DESCRIPTION OF REQUEST: 9,000 SF Dialysis Facility to be built in the city of Albuquerque

Re: Liberty Dialysis – Rio Rancho
CKA Project #11098-01
COA Project # 1009325

This letter is in response to the EPC Official Notice of Decision dated August 9, 2012. I have structured this letter stating your comments first, followed by my response in bold italics. My response is as follows:

**CONCEPTUAL GRADING PLAN**

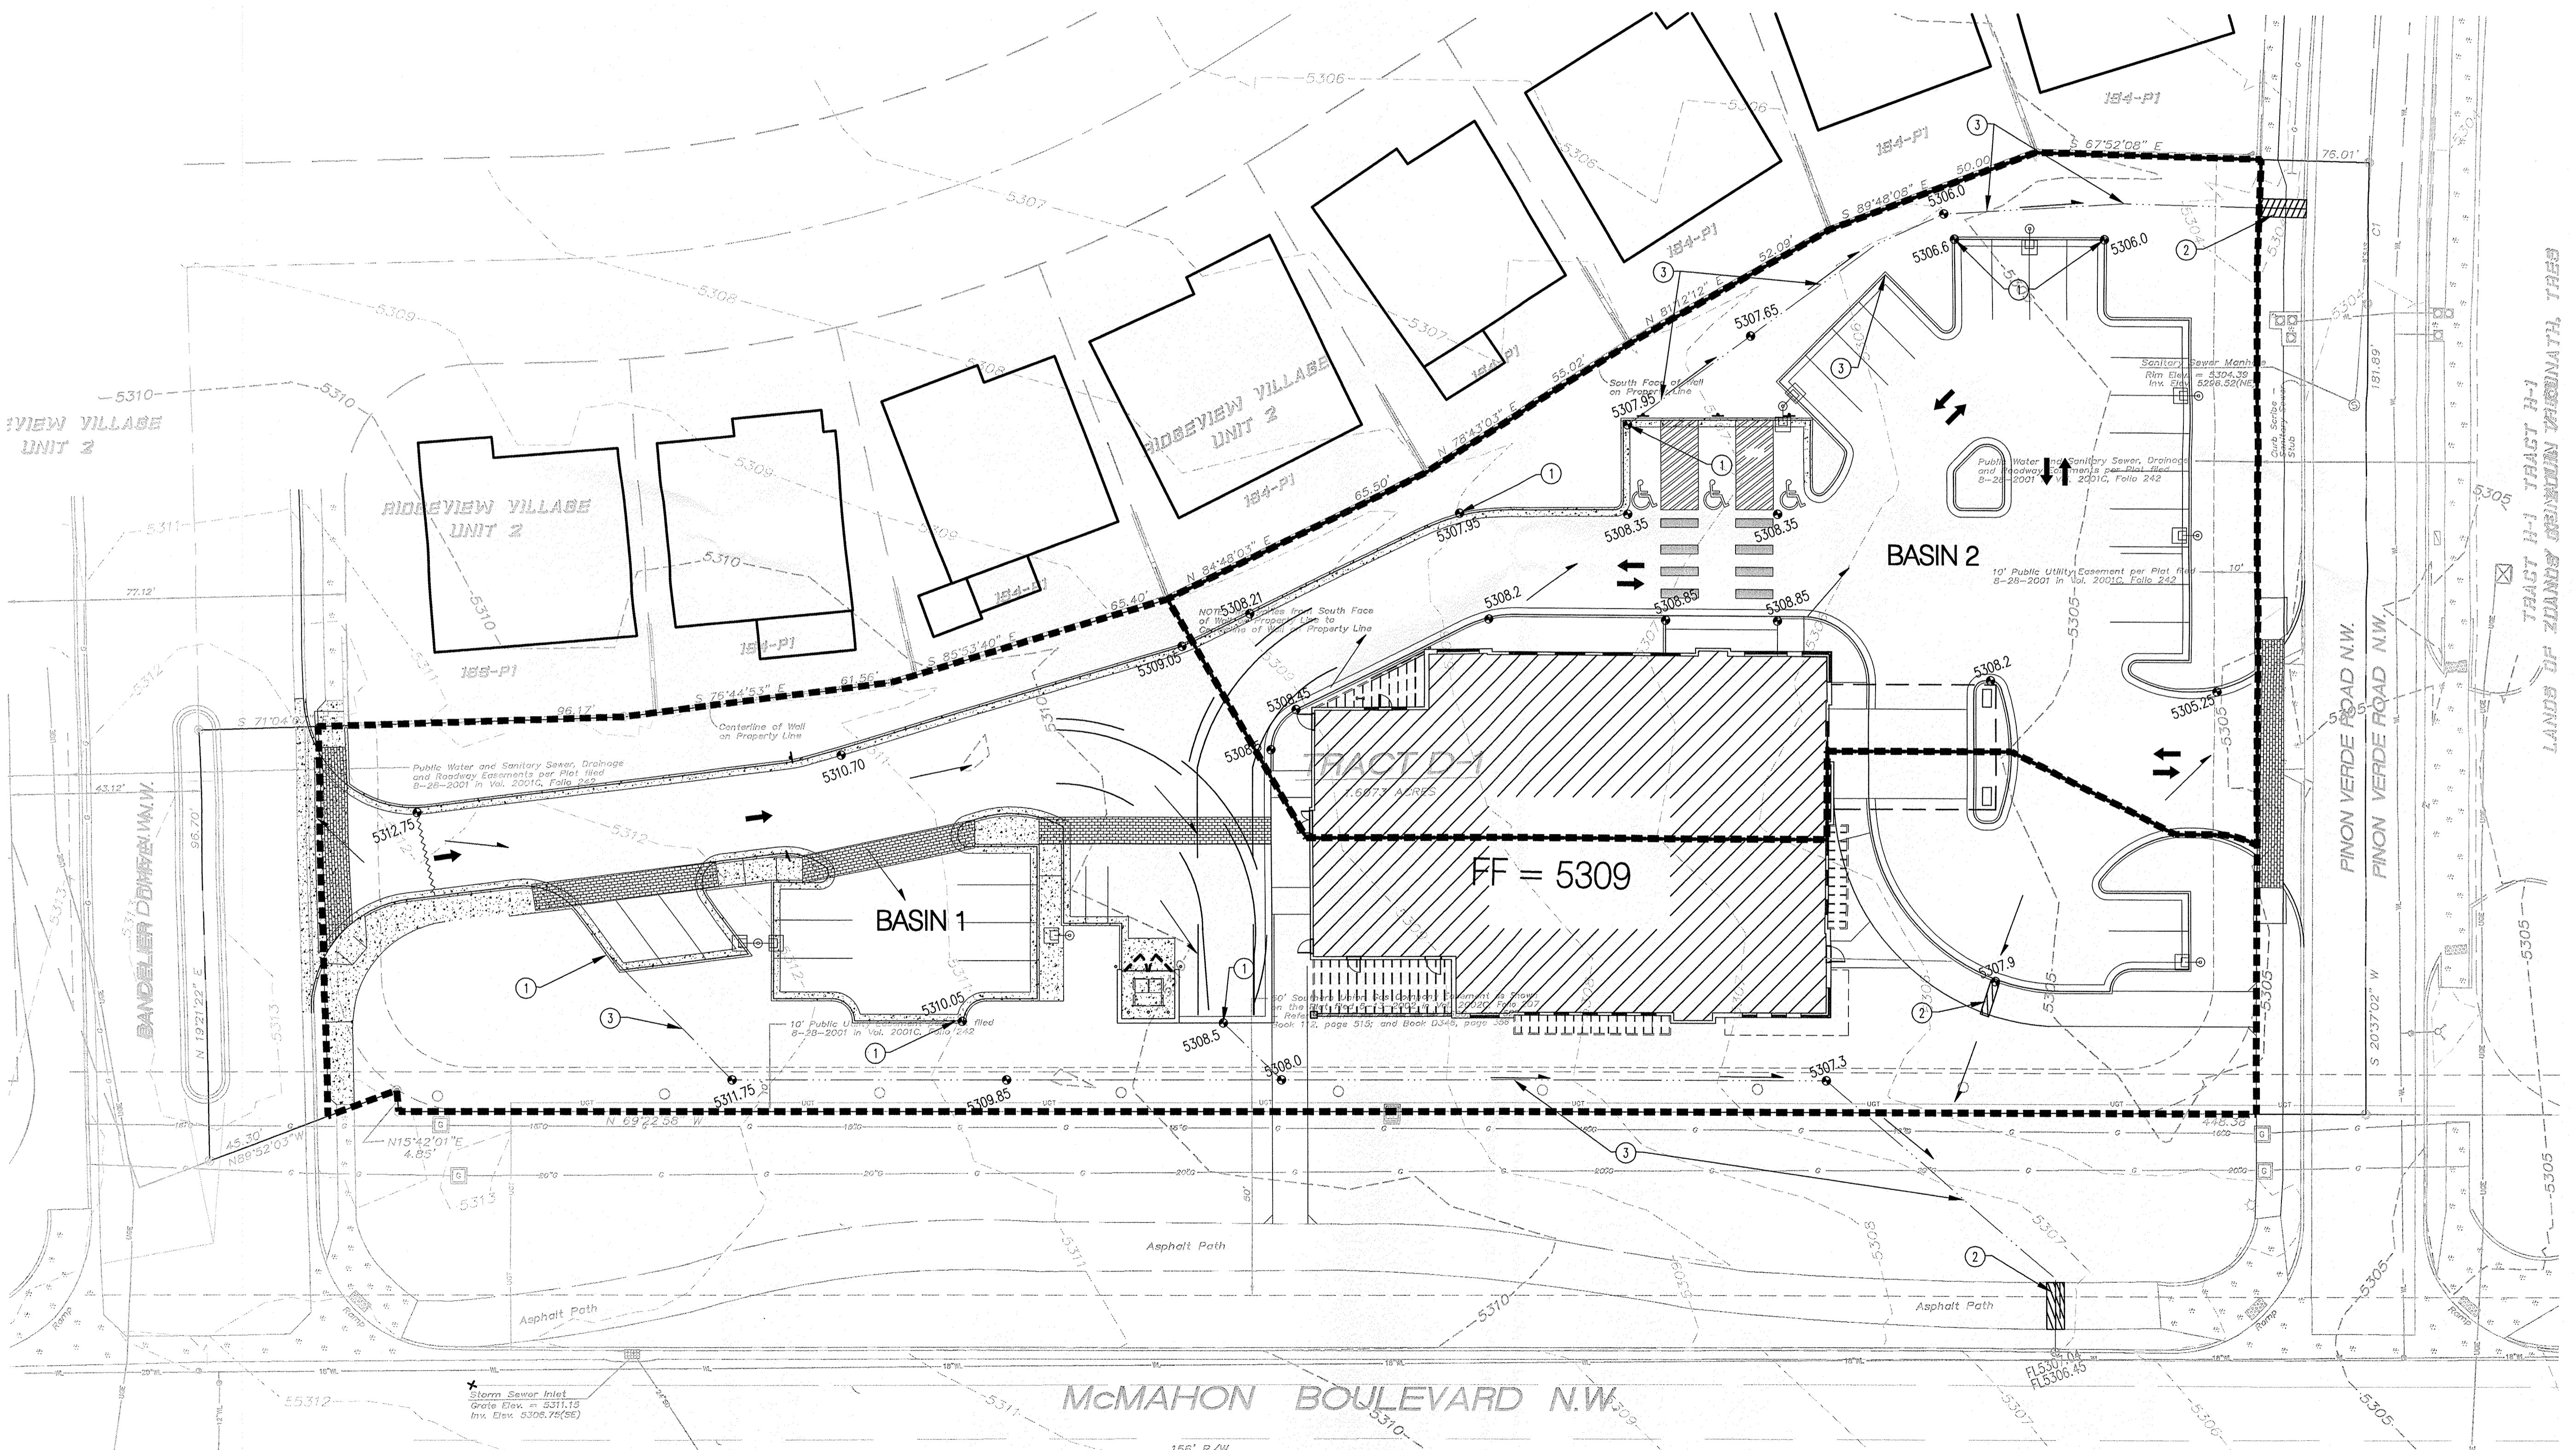
- a. Per BHI's Master Drainage Study for the Unser/McMahon Area dated 2001, this site is to drain to McMahon Blvd not to Pinon Verde Road as shown on the conceptual grading plan. This should be addressed when submitting to DRB.

The Grading Plan has been revised to direct some storm water flows to McMahon. The existing site topography is such that all flows cannot be directed to McMahon so approximately 2 cfs still drains to Pinon Verde. A submittal was made to City Hydrology on August 31, 2012 depicting this change and Sheet 3 of this submittal also includes this modification.
